**City of Portland, Maine - Building or Use Permit Application**

Permit No: 03-0702	Issue Date: <b>JUN 18 2003</b>	CBL: 087 K001001
-----------------------	-----------------------------------	---------------------

Proposed Project Description:  
Build 16x 20 studio shed w/4x20 porch

ROOF FRAMING

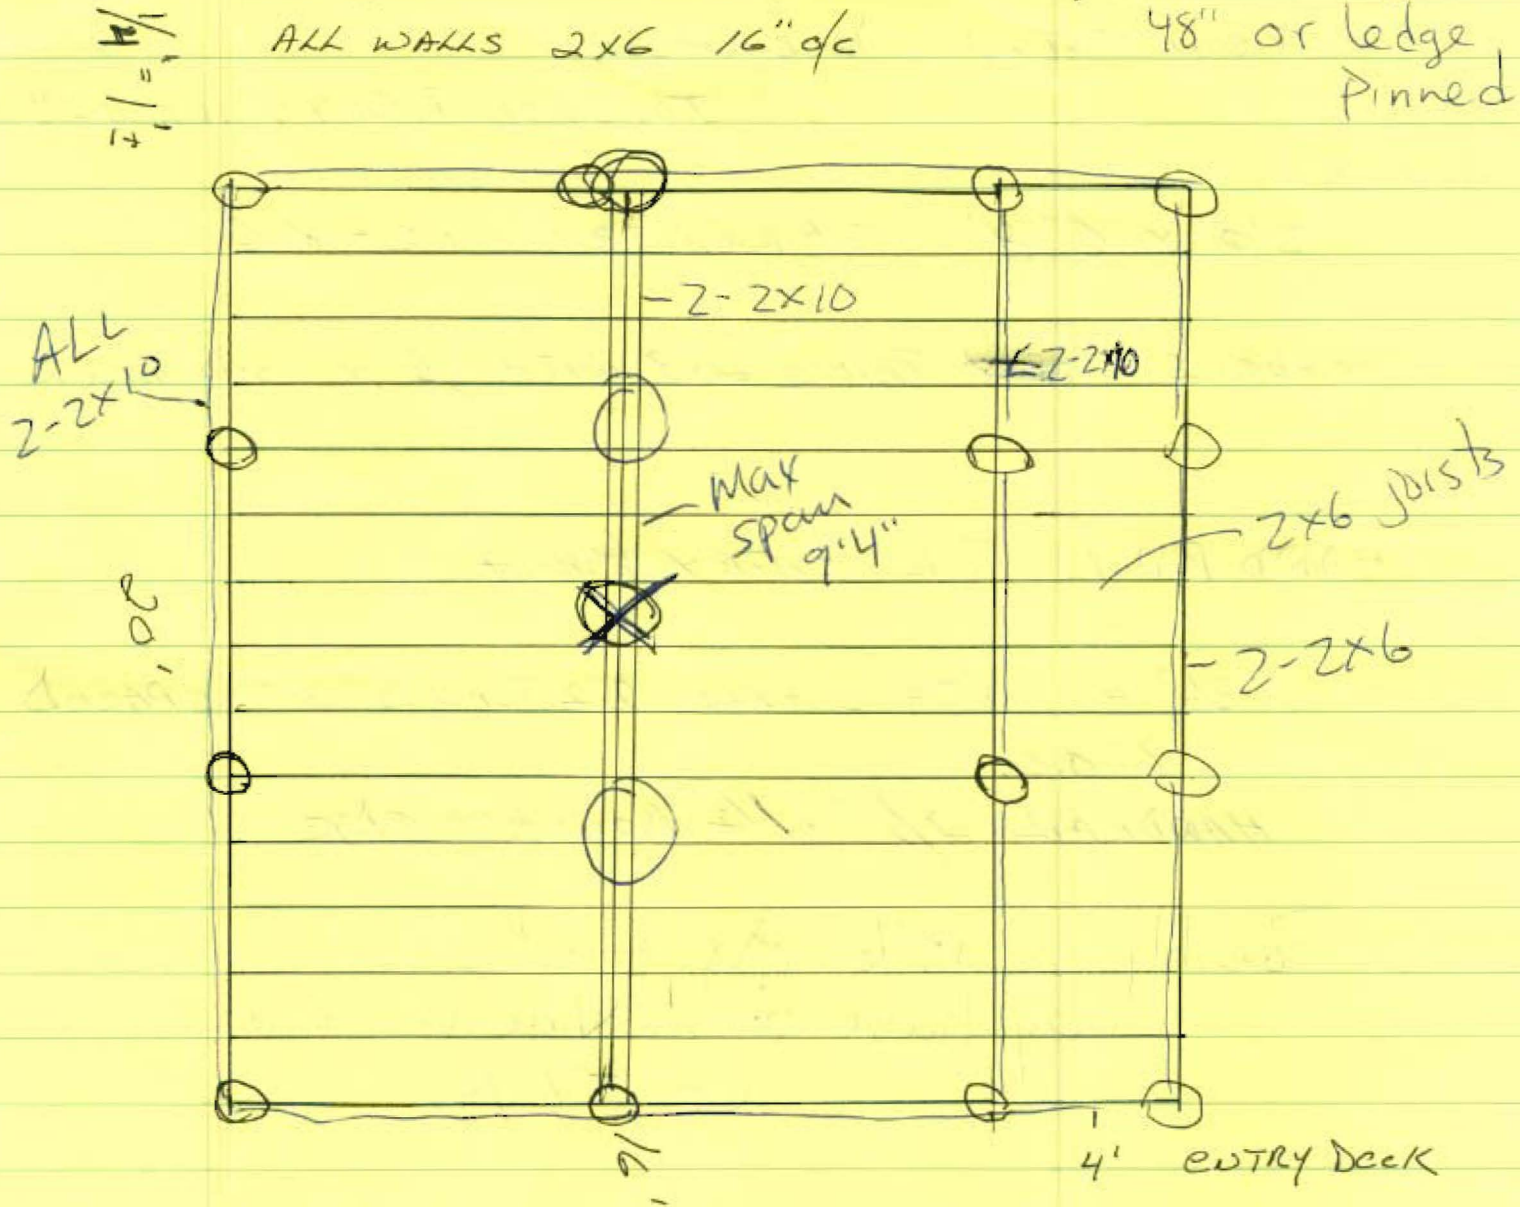
<b>Note:</b>			<b>Ok to Issue:</b> <input checked="" type="checkbox"/>
<ol style="list-style-type: none"> <li>1) Design load specs for the engineered ridge shall be submitted to this office</li> </ol>
